Application no: 23/01493/REM

Location: Proposed Himley Village North West Bicester, Middleton Stoney Road, Bicester

Transport Schedule

TITLE  
PHASE 1B  
BUS SWEPT PATH ANALYSIS  
SHEET 1

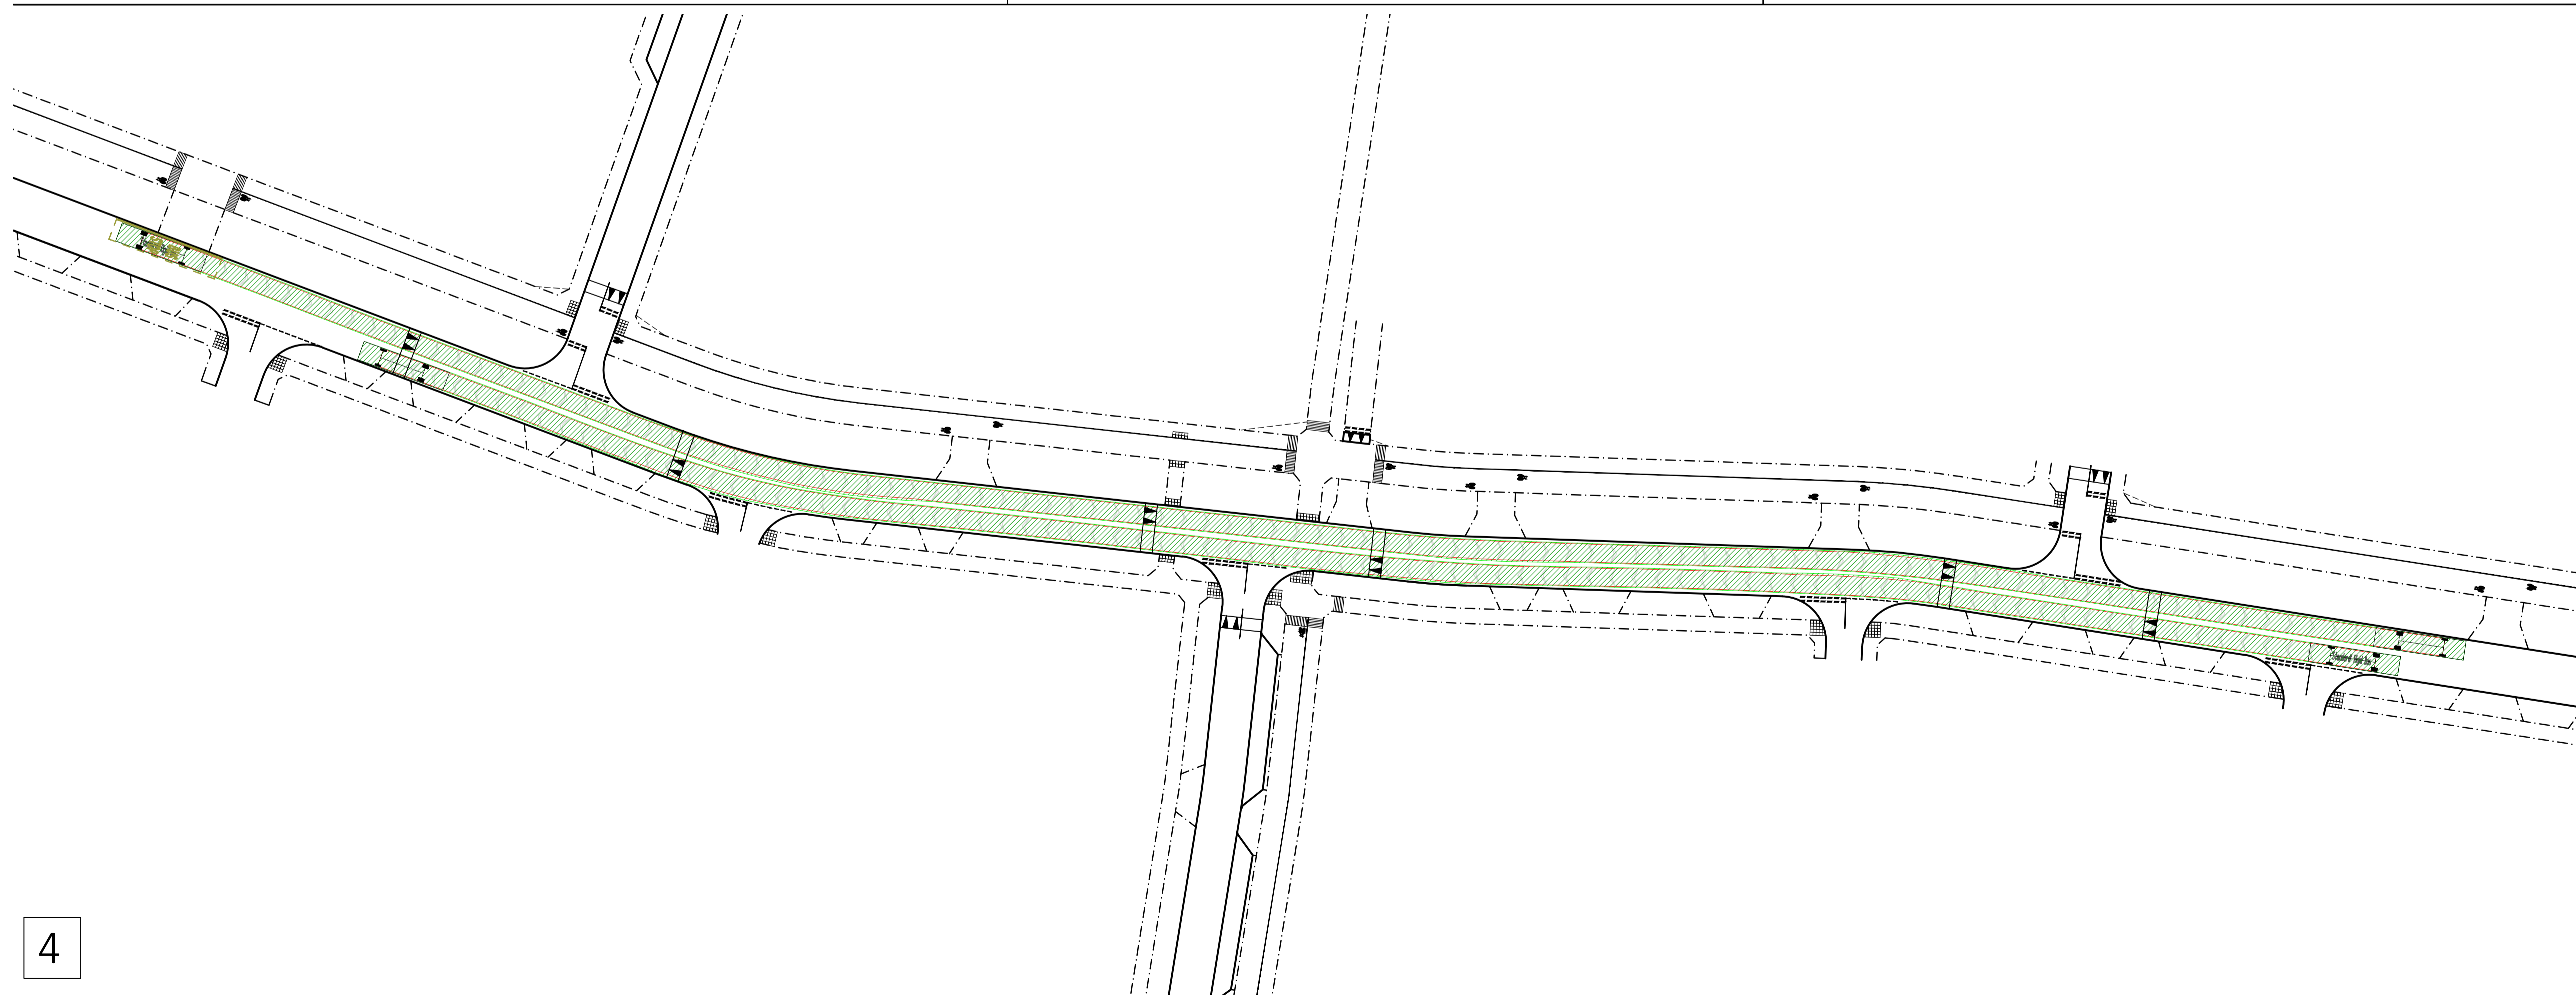
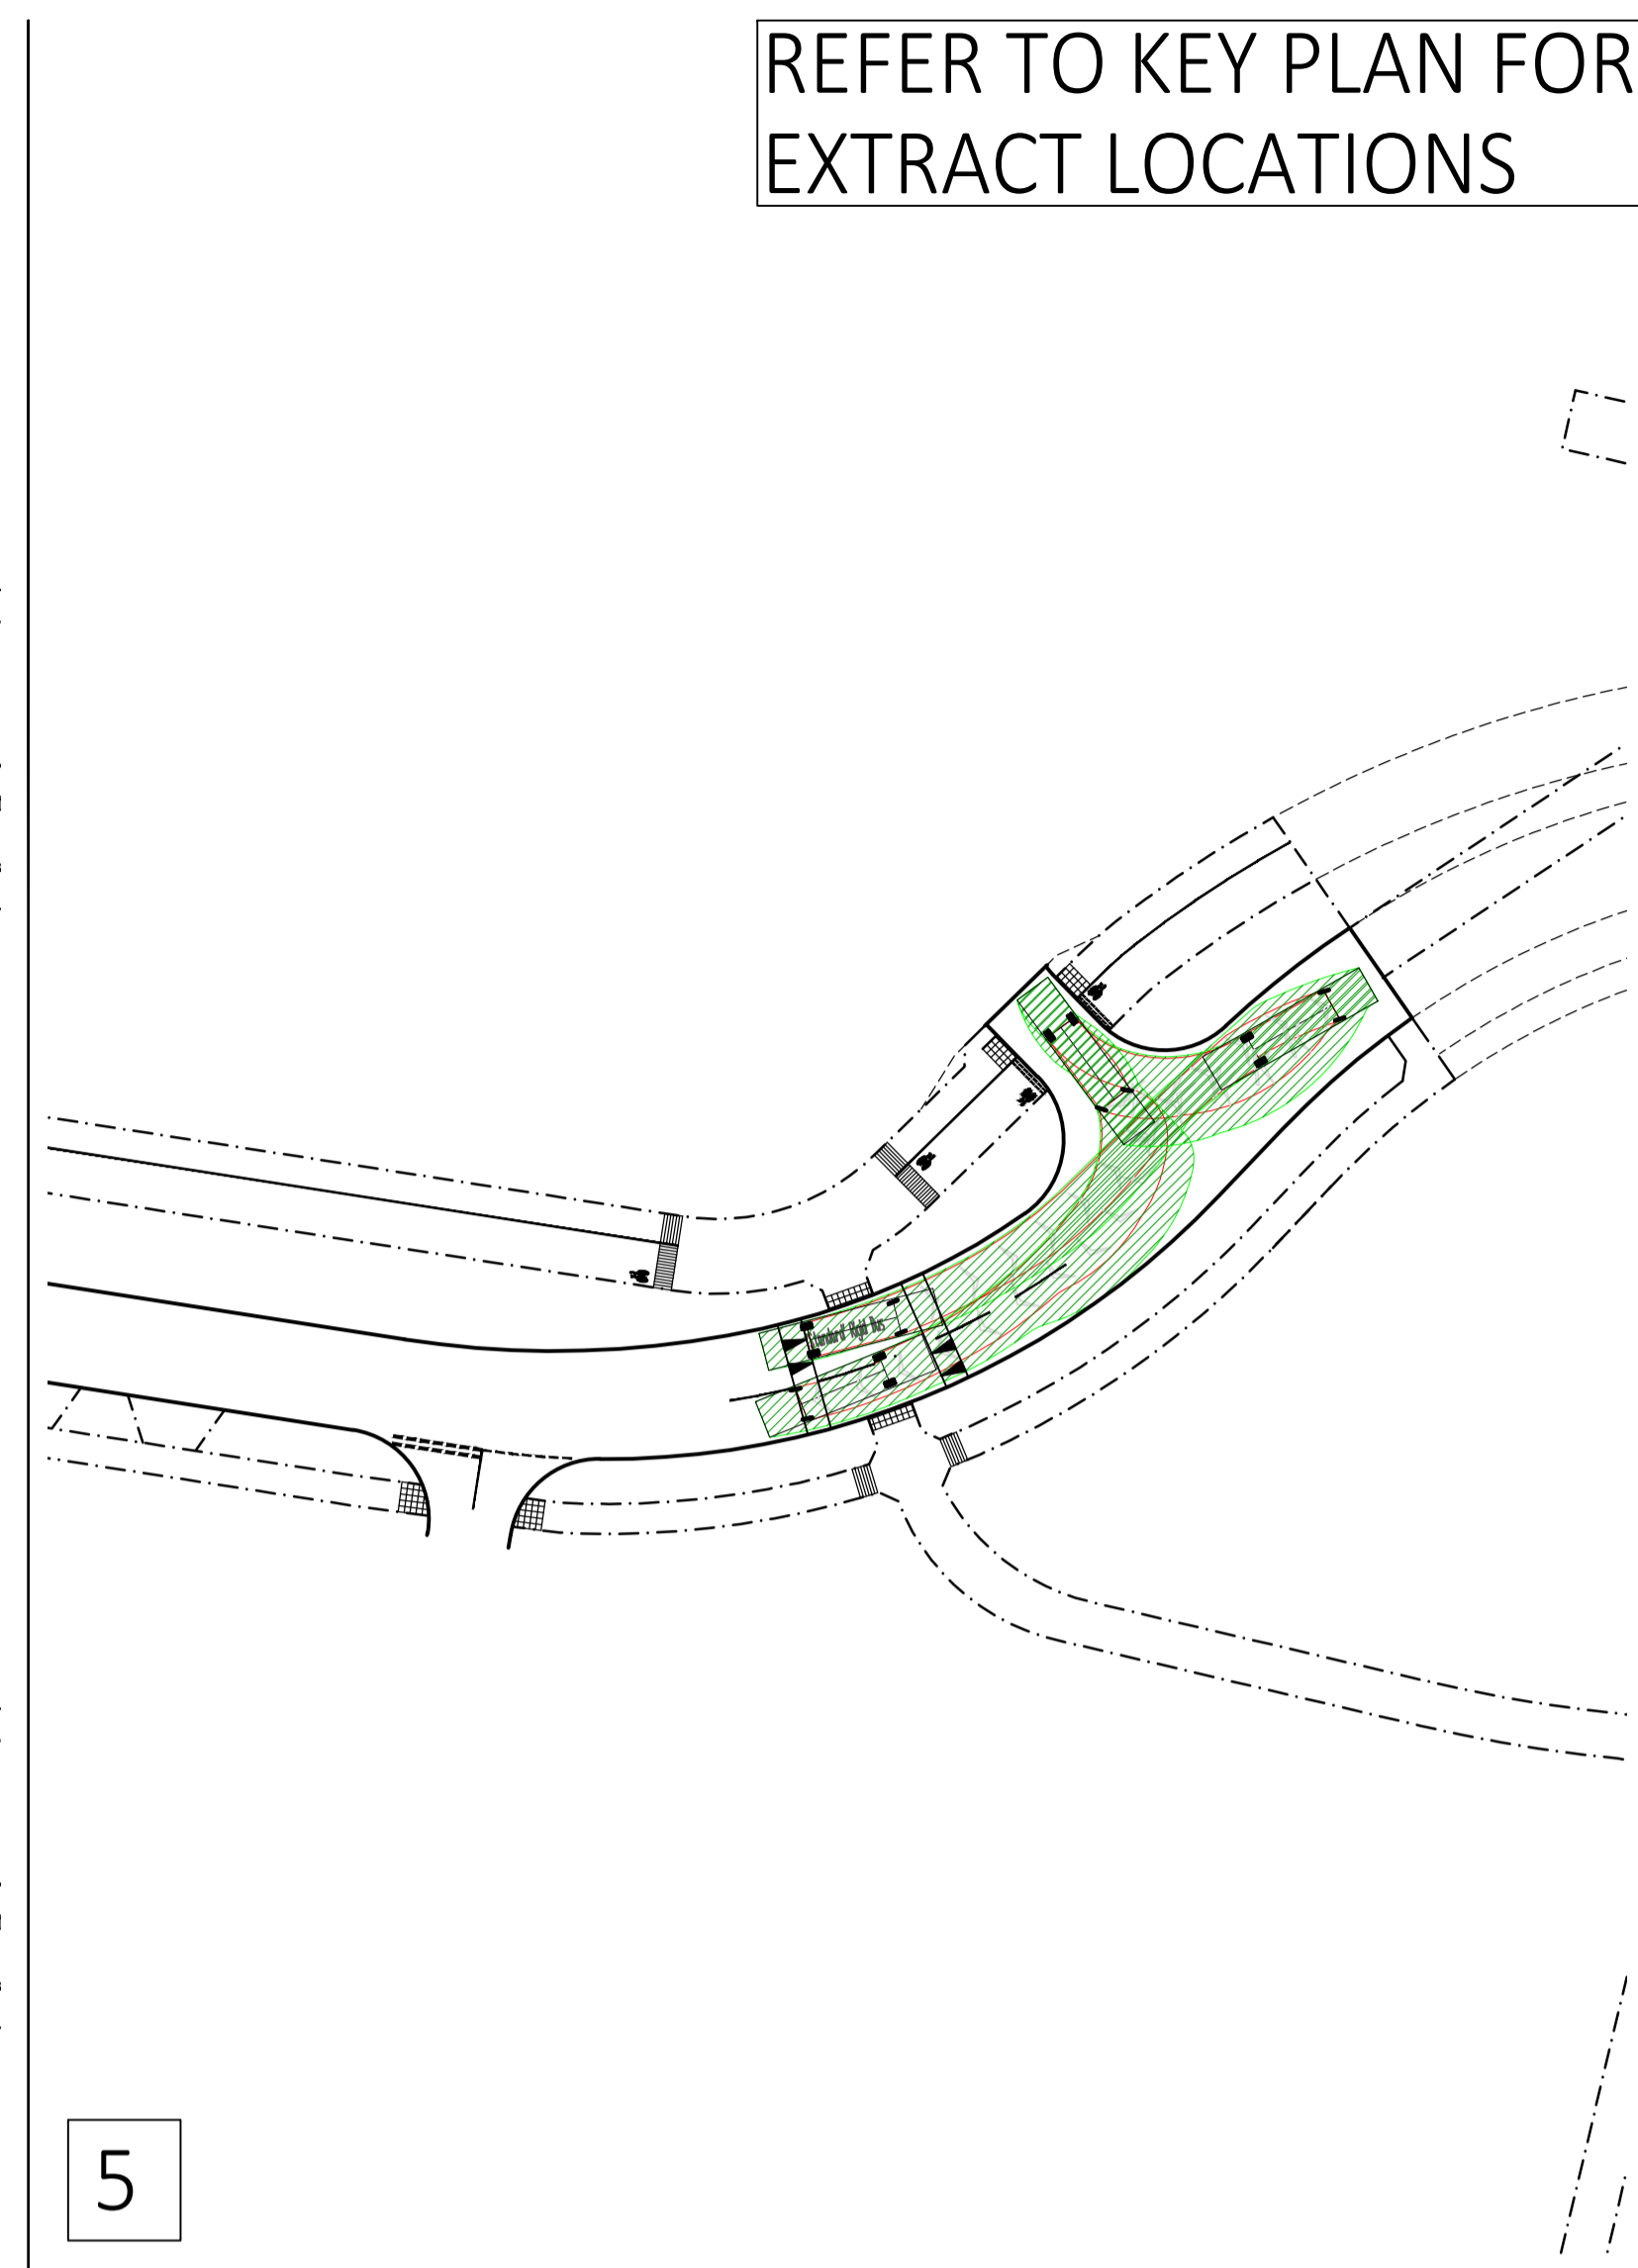
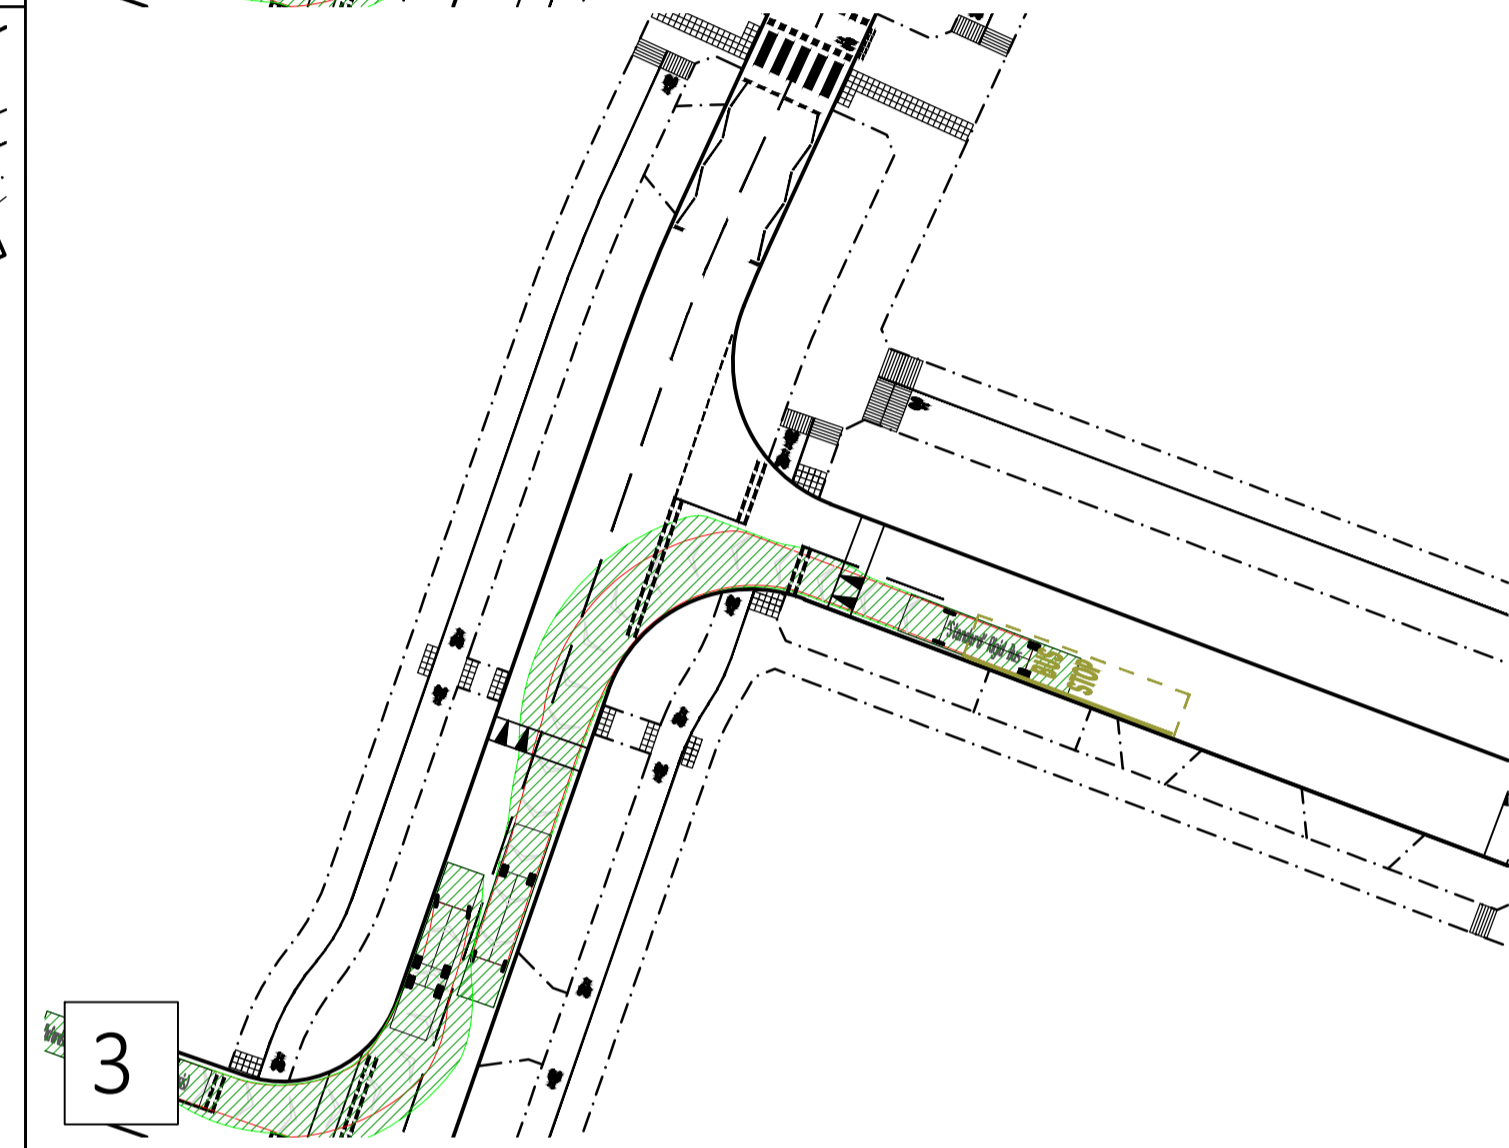
I previously explained that the temporary bus turning heads were not acceptable as it would require buses reversing over the raised cycle crossings. After discussions with the applicant, it has been agreed that the raised cycle crossings at the northern end of the Spine Road North - South and at the eastern end of the Spine Road East - West will be implemented when Oxfordshire County Council have confirmed that the requirement for the use of the temporary bus turning heads has ceased.

In addition, the raised crossings at the western end of the strategic secondary streets will be implemented when these roads connect to Phase 3 and Oxfordshire County Council have confirmed that the temporary turning heads are no longer required. Insets on the Engineering Layout Sheets 1 to 4 include the layout of all the temporary turning head as well as the agreed final layout.

A condition to this effect has been included.
